**From:** Rich Elliott <elliotttr@kvfr.org>  
**Sent:** Tuesday, January 27, 2015 4:55 PM  
**To:** Lindsey Ozbolt  
**Cc:** Joe Seemiller; John Sinclair  
**Subject:** RE: Notice of Application (SD-14-00004 & PF-14-00002) Canyon Interpretive Center

**Subject:** Notice of Application (SD-14-00004 & PF-14-00002) Canyon Interpretive Center

[SD-14-00004 Canyon Interpretive Center](#)

1 SITE PLAN
1" = 80'-0"

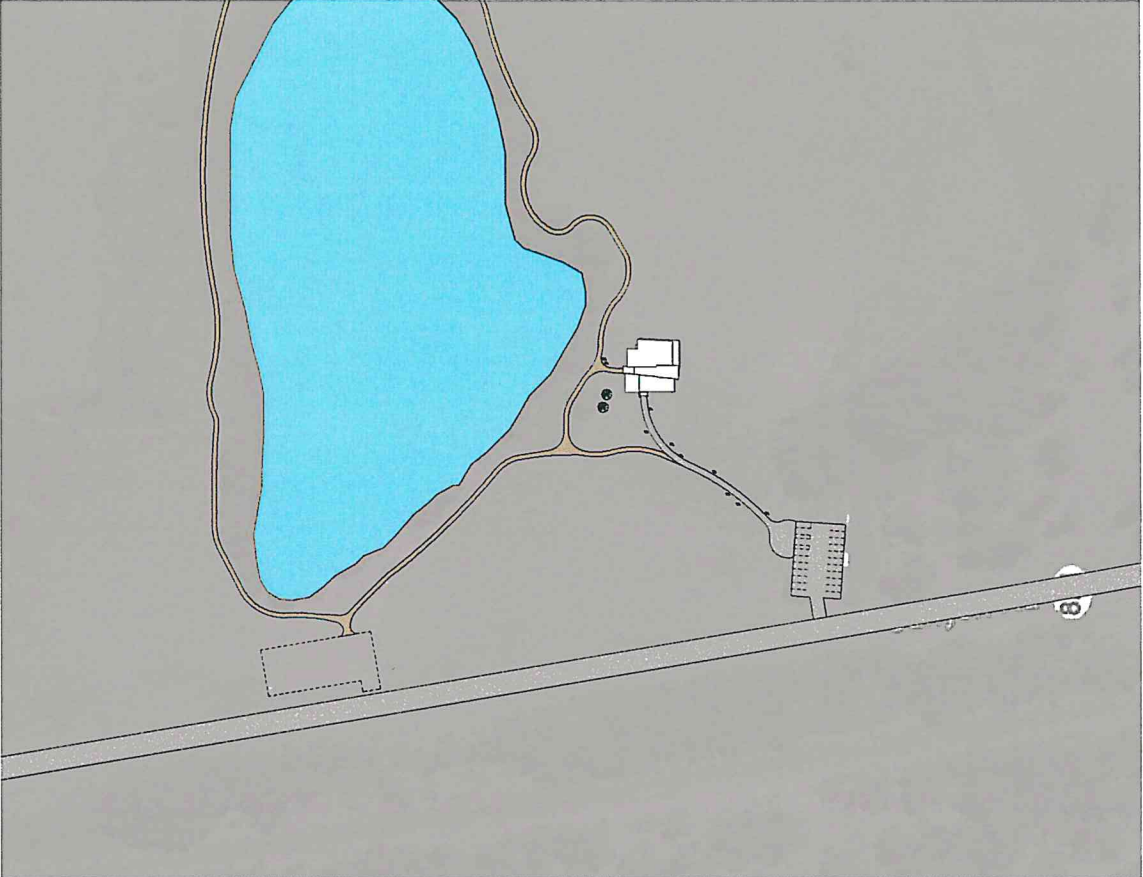
1. Addressing clearly visible from both directions of travel on SR 821
2. Sprinkler and fire alarm systems may be required. If so, KVFR would like to have input into location of components.
3. Access compliant with Appendix D – current fire code when permit issued.
